Peartree Hill Solar & BESS Technical & Safety Concerns From: George Swallow, CEng MIChemE<sup>[1]</sup>

To: The Examining Authority, Planning Inspectorate<sup>[2]</sup> Deadline: 31 October 2025<sup>[3]</sup> Reference:

Peartree Hill Solar NSIP Application Ref EN010157 Registration reference number F693DA89E Oral submission hearing 23rd October 2025 Introduction Thank you for the opportunity to raise concerns about Battery Energy Storage System (BESS) safety regarding the Peartree Hill Solar & BESS facility - Planning Application Ref EN010157.<sup>[4]</sup> I am a Chartered Chemical Engineer with professional experience in process-safety and loss-of-containment risk assessment. This written submission follows up my earlier representations and sets out further technical questions and evidence-based concerns regarding the Applicant's BESS proposals.<sup>[5]</sup> It focuses on: 1. adequacy of the Major Accidents and Disasters (MA&D) assessment; 2. environmental and groundwater protection; 3. compliance with National Fire Chiefs Council (NFCC, 2023) and UK Government (2023) guidance; and 4. verification of safety-instrumented systems and emergency-response provisions. Context from S

Figure 3.1: Indicative Operational Layout Plan

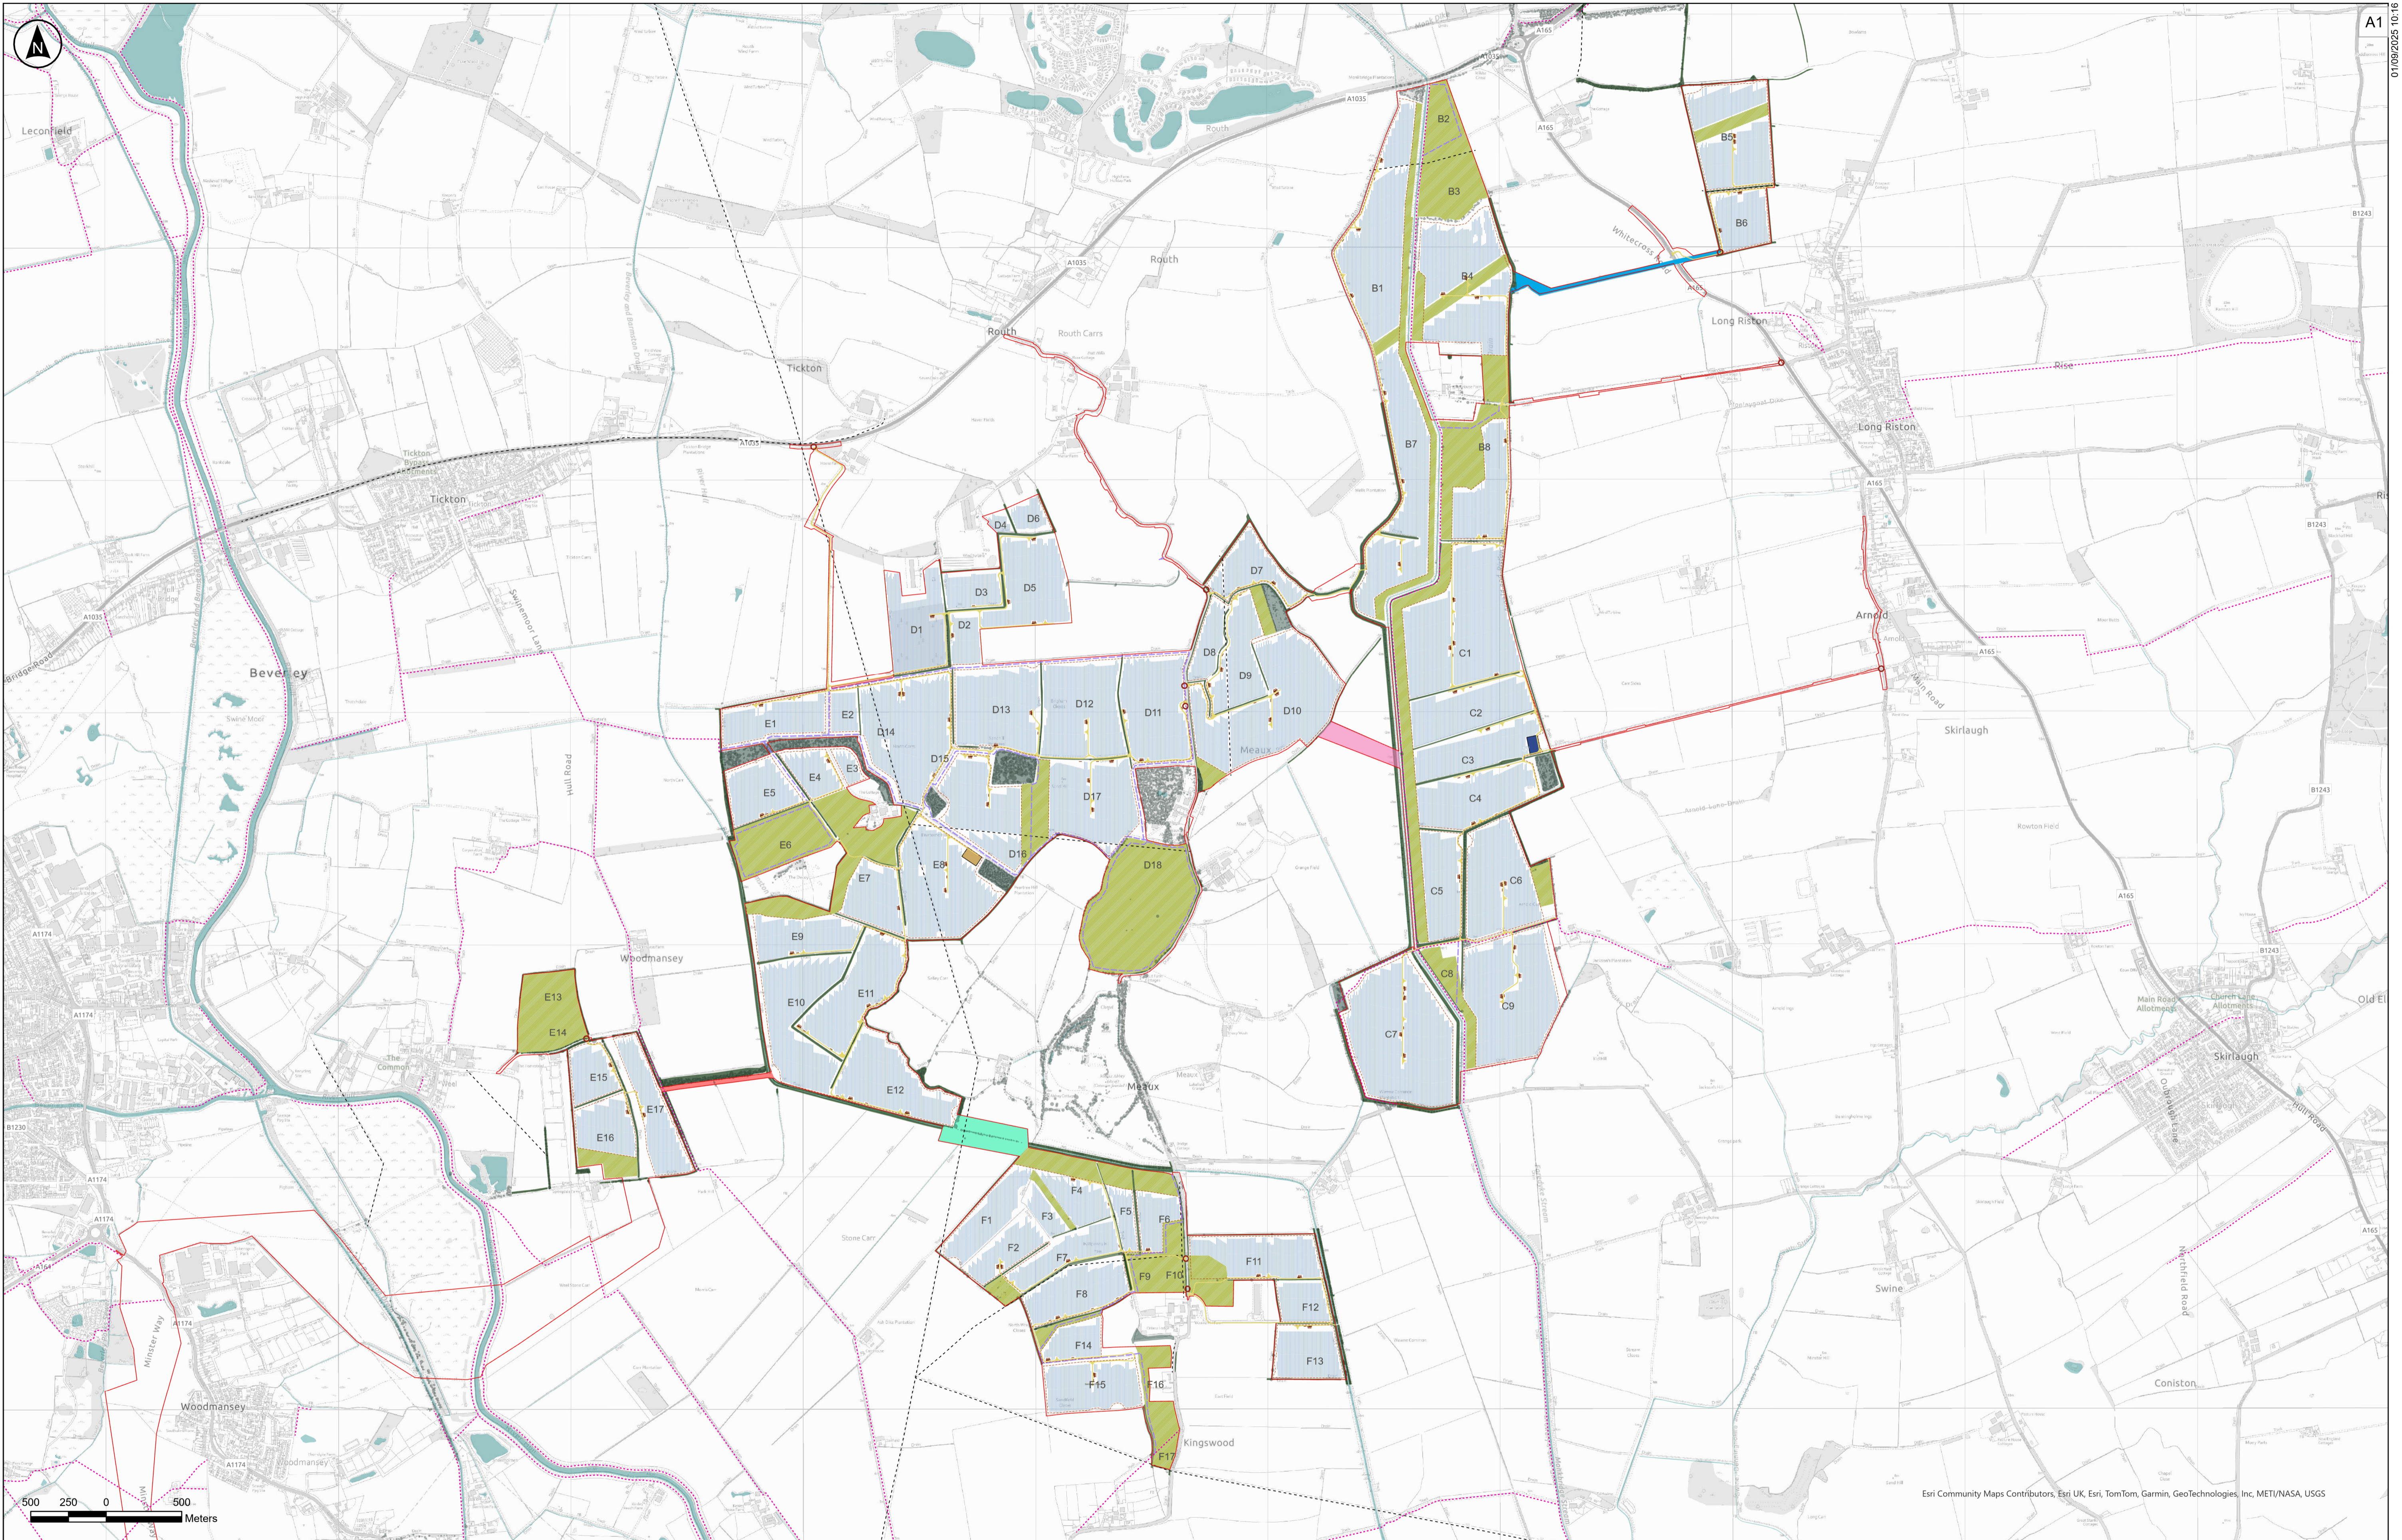
9. Access, Egress, and Geometry Provide plans showing two independent access routes allowing for opposing wind directions and sufficient turning circles for FRS appliances. The Outline Battery Safety Management Plan (Appendix 1, Table 1, p. 21) indicates 3 m between BESS units; justify this spacing against the NFCC suggested 6 m minimum or present equivalent engineering mitigations.

10. Design-Basis Data for BESS Containers For each BESS container type, provide manufacturer, model, energy capacity (MWh), cell chemistry, electrolyte inventory, deflagration-vent design, door fire rating, and separation distance used in fire engineering analysis. Cross-reference to general-arrangement drawings. <sup>[1,3]</sup> Edwards and Dobson (2024) note that insufficient public transparency regarding BESS design parameters is a recurring safety weakness in UK projects [1].
